# **M3 Junction 9 Improvement**

**Scheme Number: TR010055**

## **5.1 Consultation Report Appendix E - EIA Scoping**

# **SCOPING OPINION:**

**PROJECT STAGE**  
 PCF STAGE 3

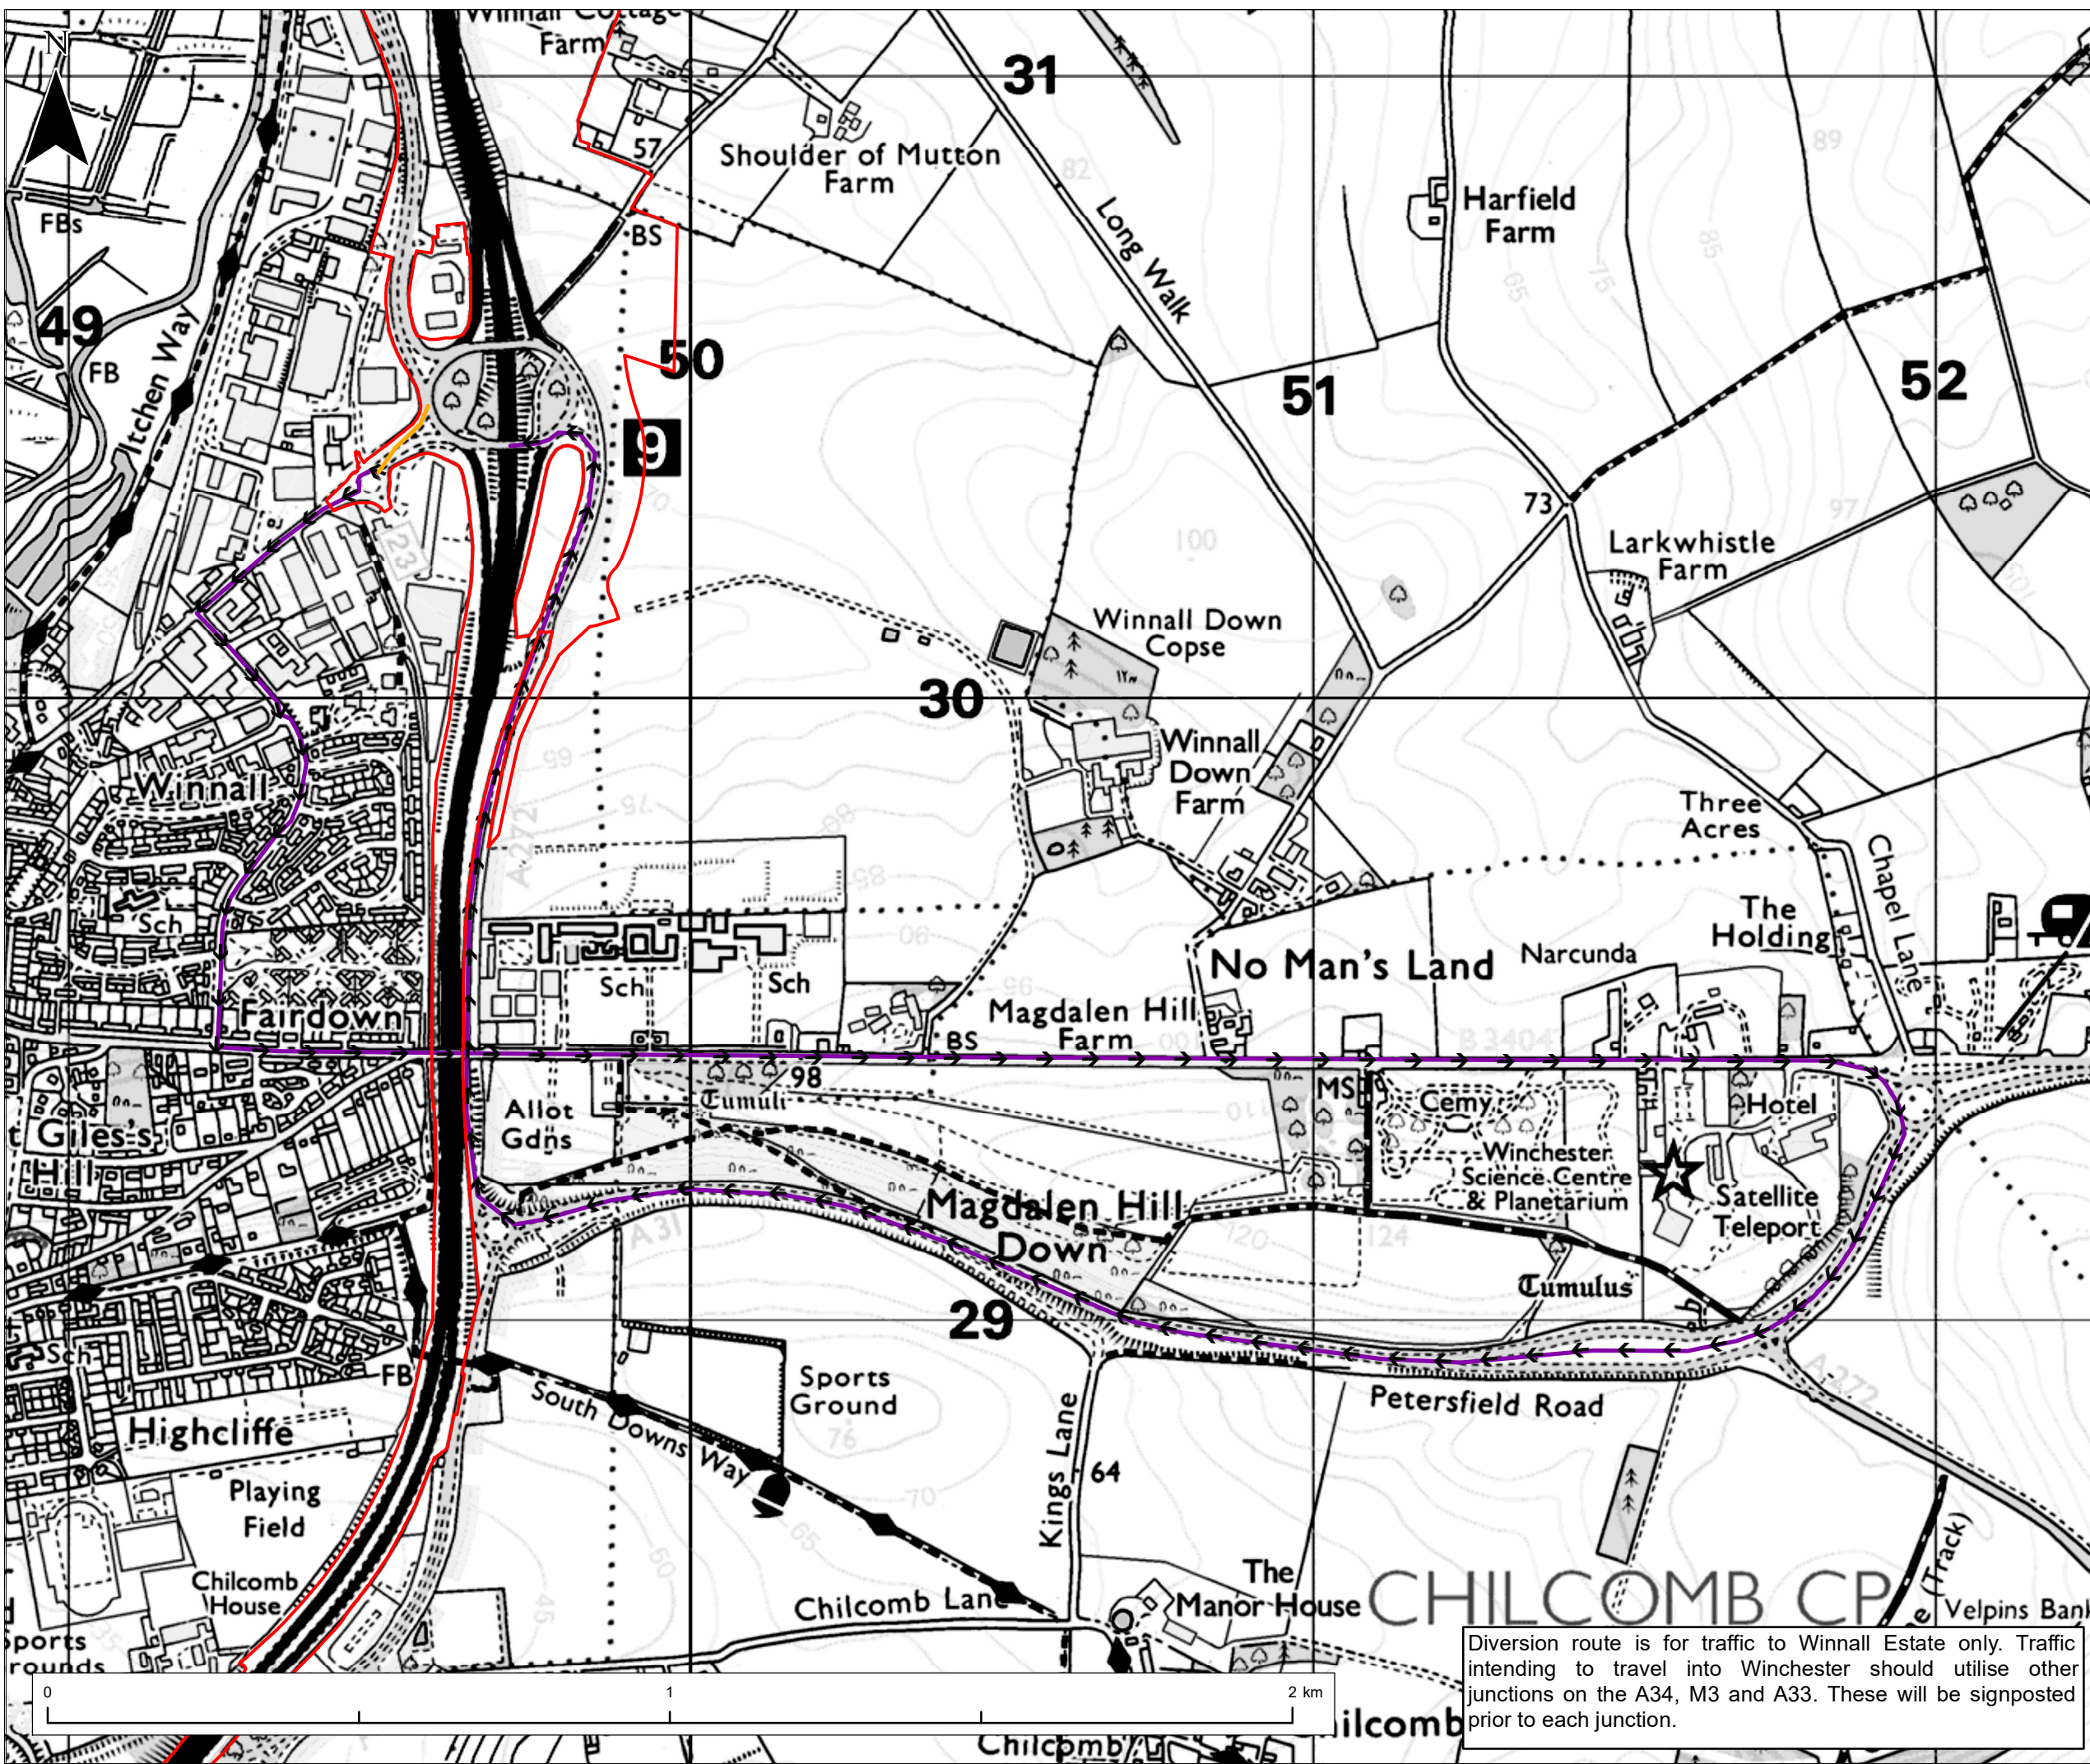
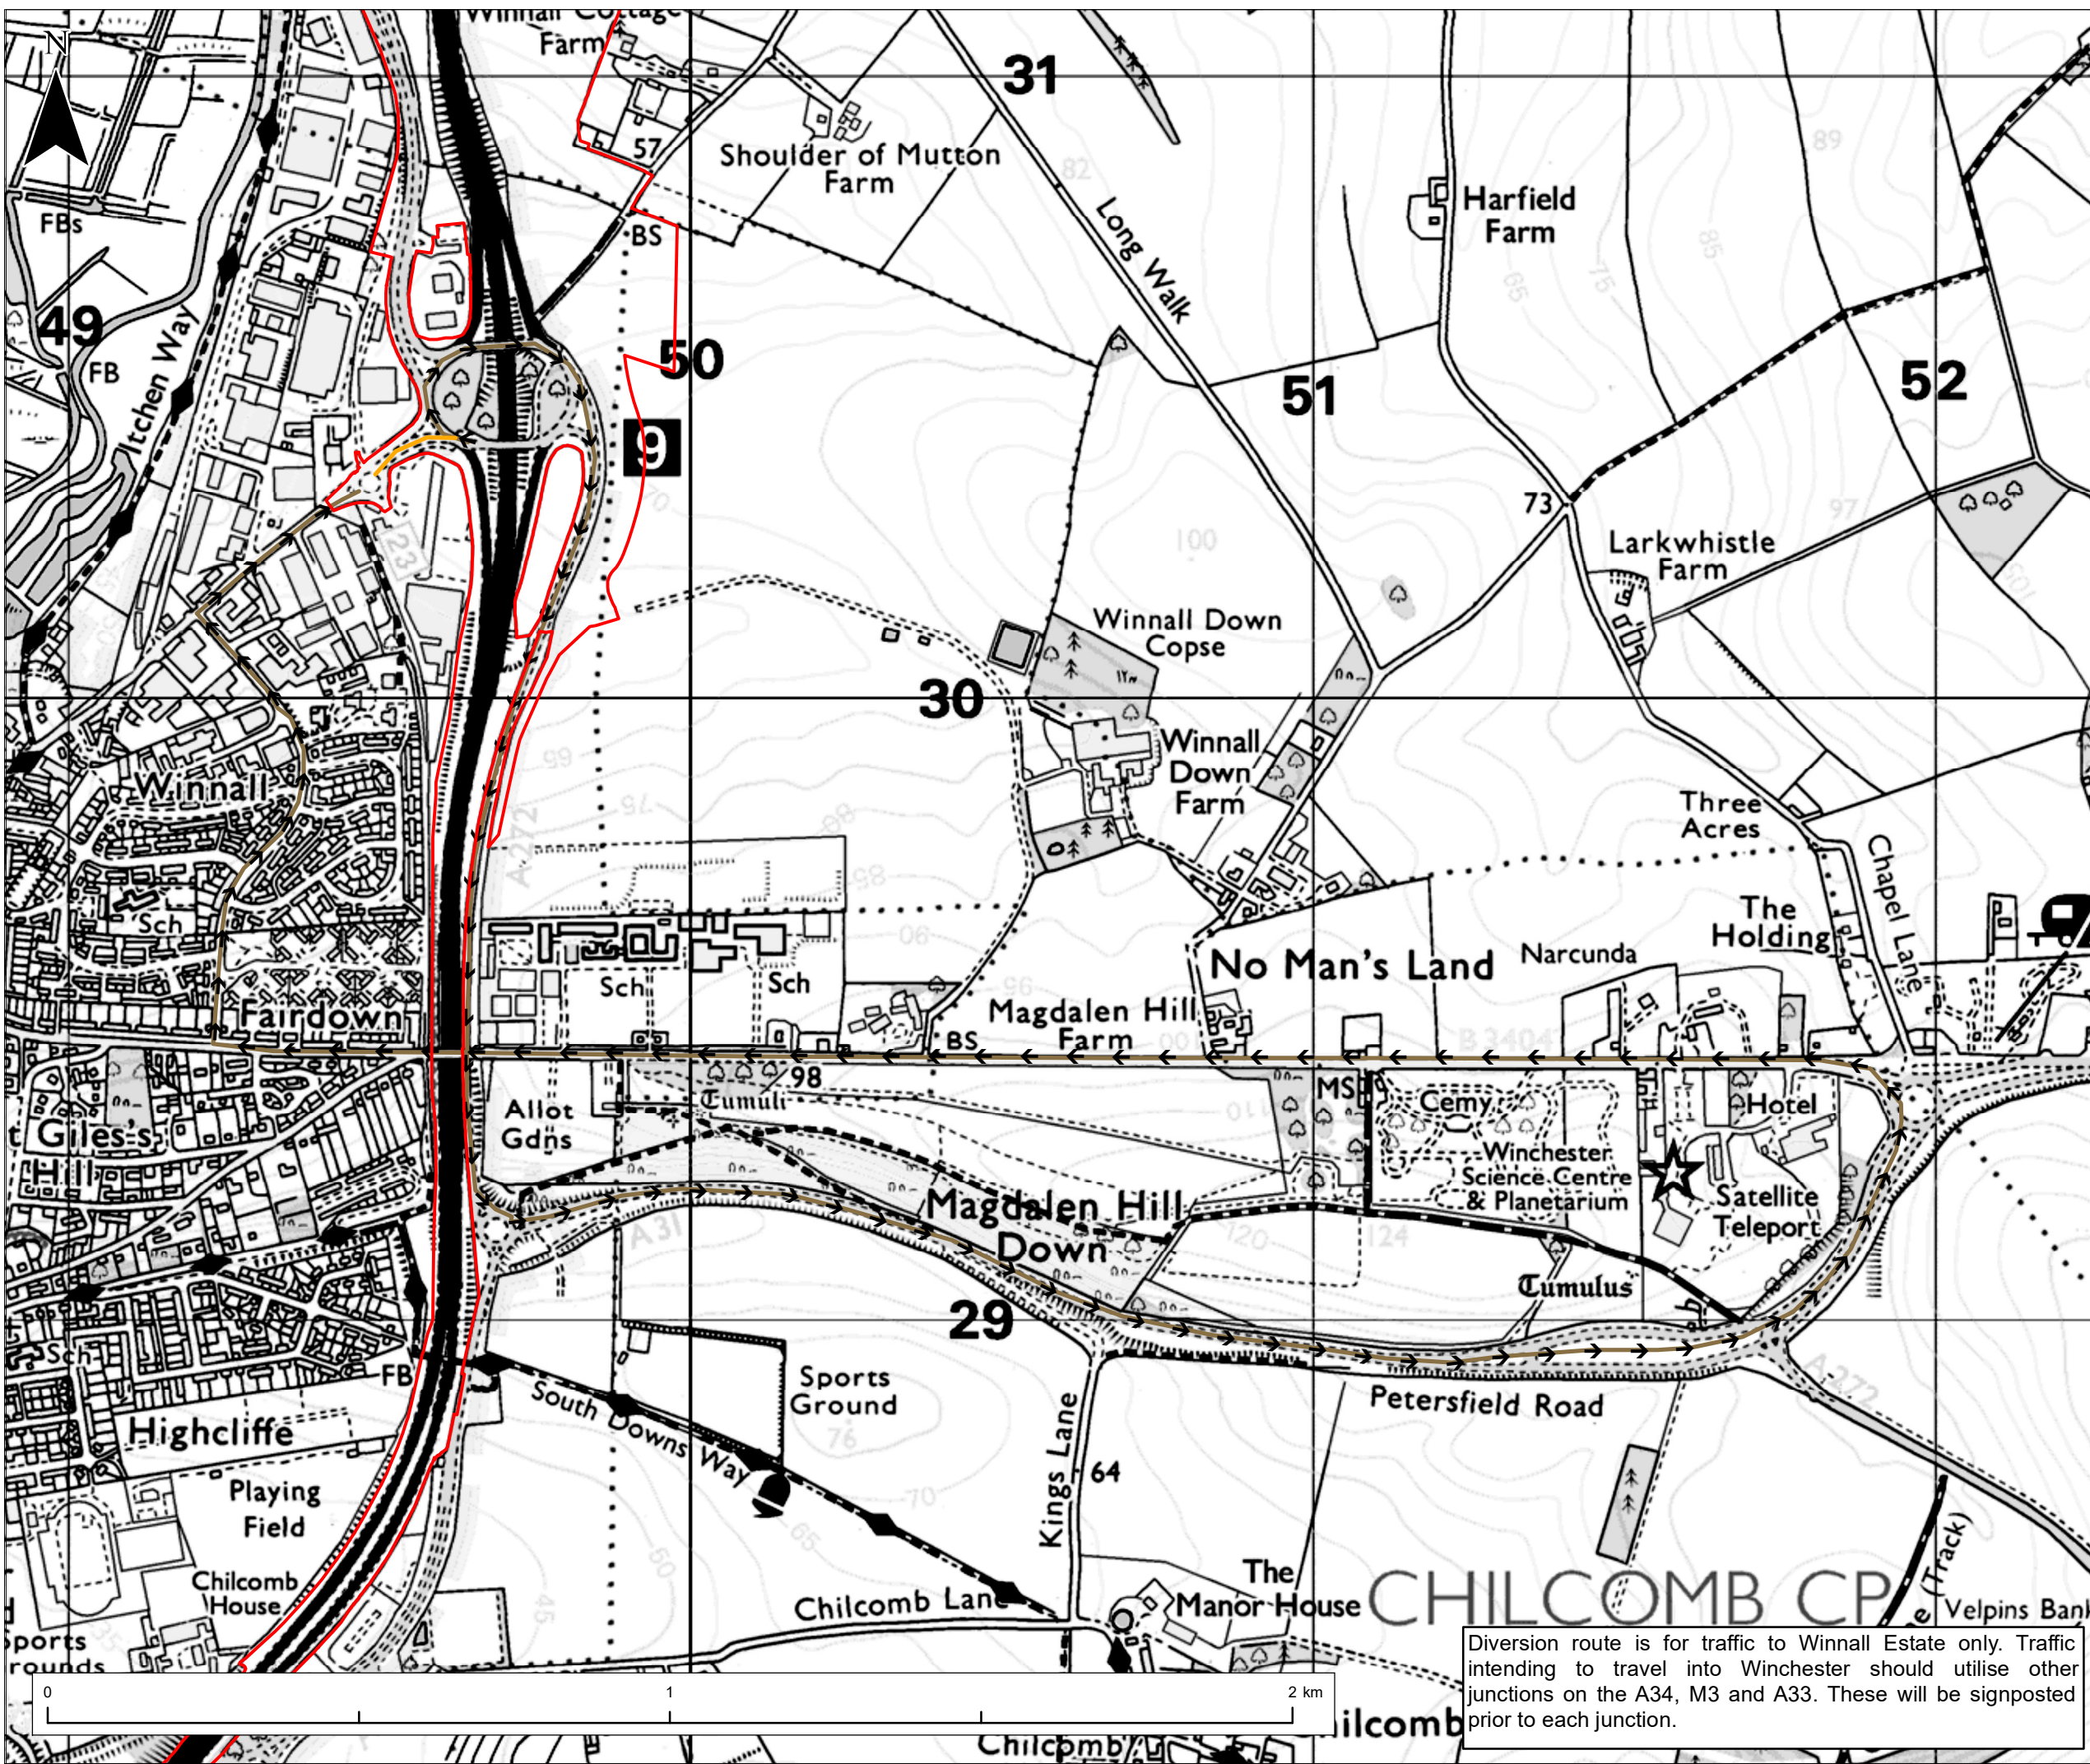
- 2.3.7 Diversions and closures of roads are listed to be required throughout in the construction phase. The ES should contain a full explanation of such closures and diversions, including whether they are temporary or permanent, and associated impacts should be fully assessed. This should also include any closures or diversions to Public Footpaths or Rights of Way.
- 2.3.8 This information should also be depicted on figures in the ES, to provide further clarity.
